From: Anita Gardner
Sent: 14 December 2018 14:17
To: Karen Parsons
Subject: FW: LU/260/18/HH 22 Roman Acre, Littlehampton
Attachments: 1179.02.d Proposed A1.pdf

From: Lauren Willard [REDACTED]
Sent: 13 December 2018 17:37
To: Anita Gardner
Subject: LU/260/18/HH 22 Roman Acre, Littlehampton

Site Block Plan (1:500)

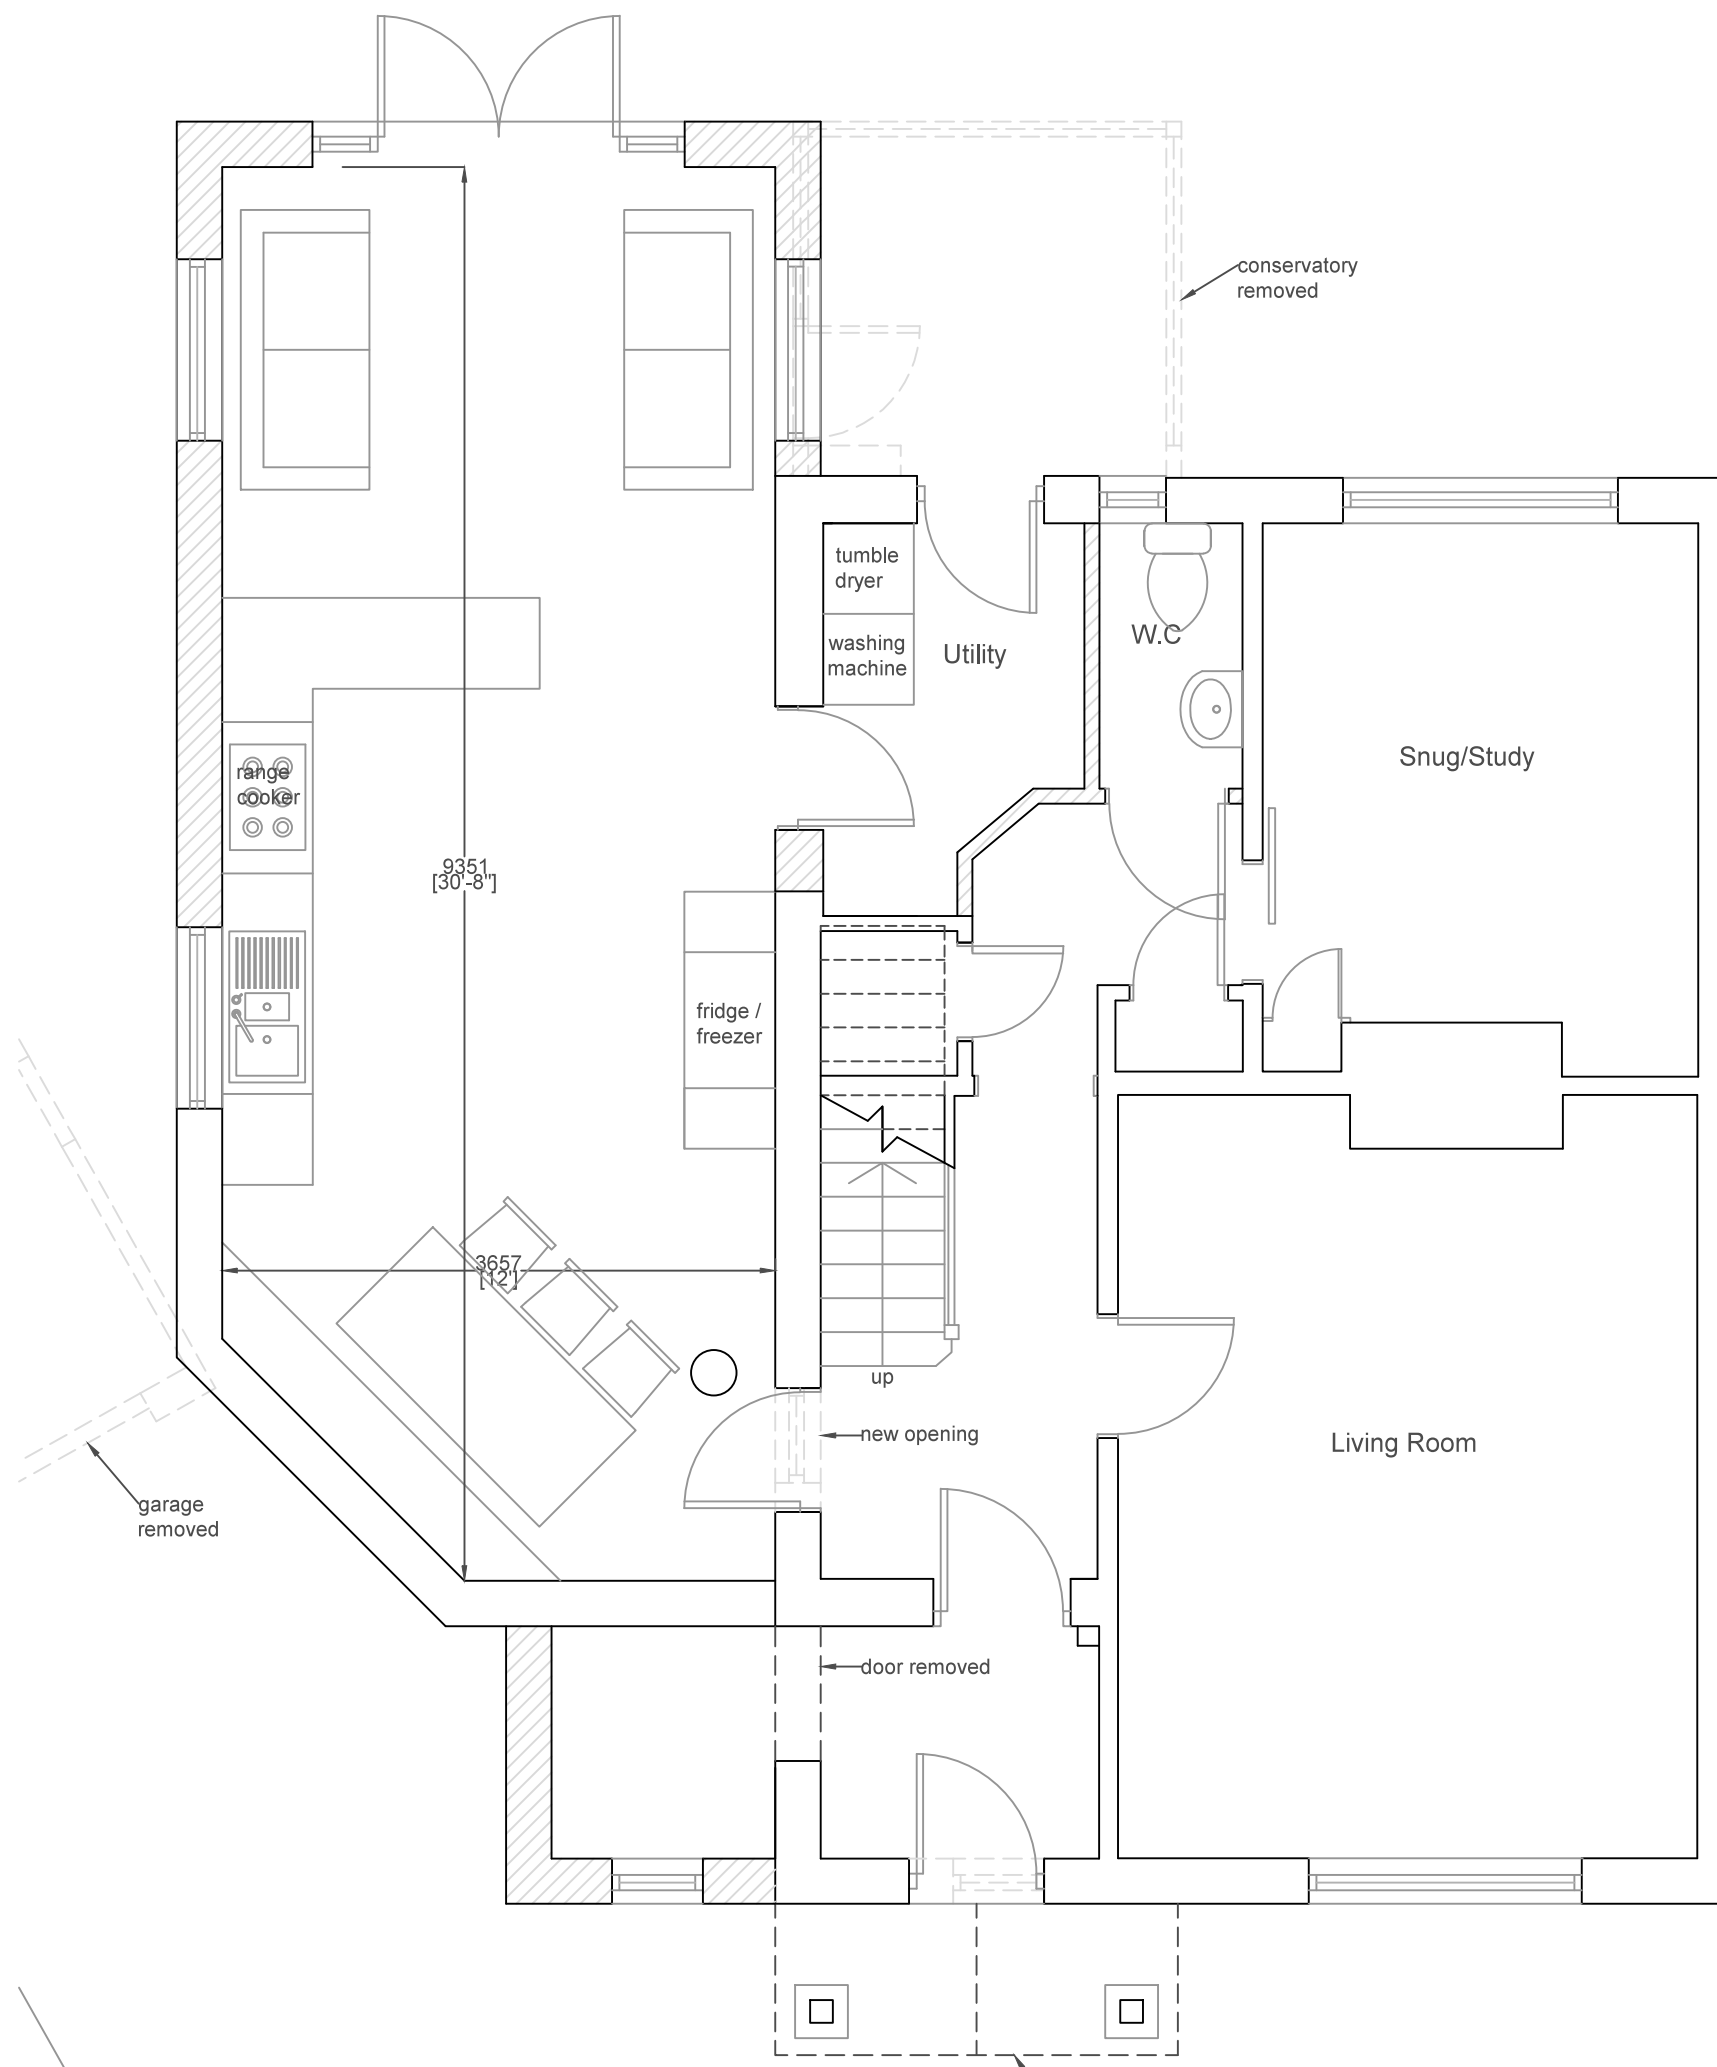
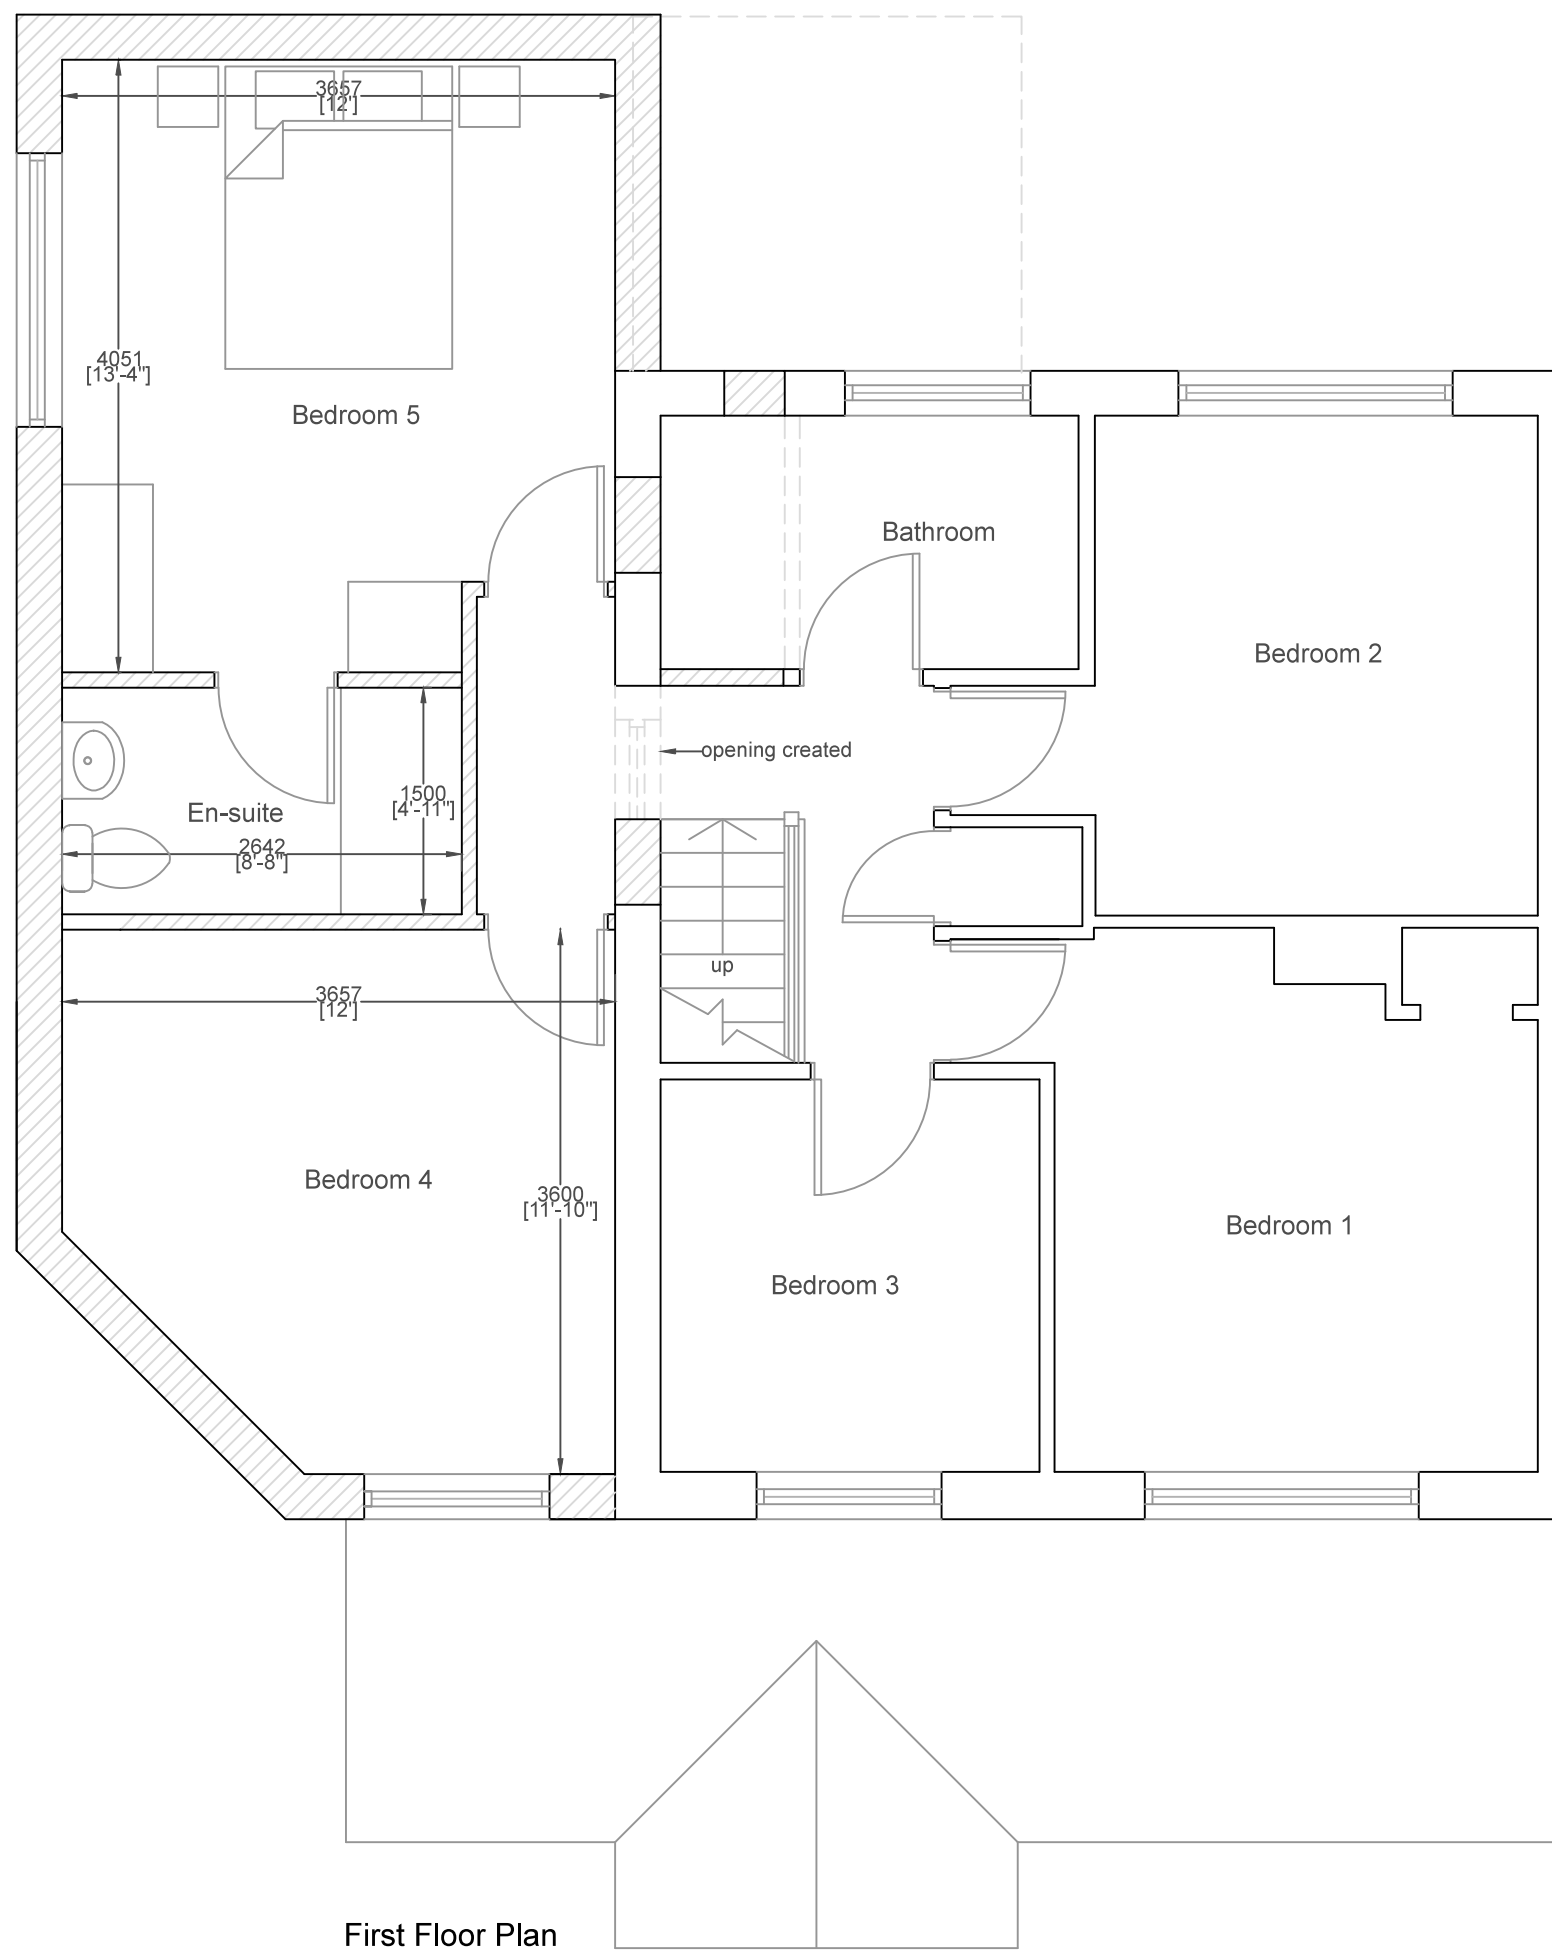
There is a change that the client would potentially like to move the side of the proposed extension out to the side of the property by an additional 300mm would it be possible to substitute a revised drawing for this? I will be able to get this to you tomorrow (Friday) if you would accept it.

Please find attached the amended drawing that we would like to substitute.

I can agree to accept revised plans showing this alteration as long as you agree to an EOT until the end of next week 21-12-2018 to allow for receipt and processing of plans.
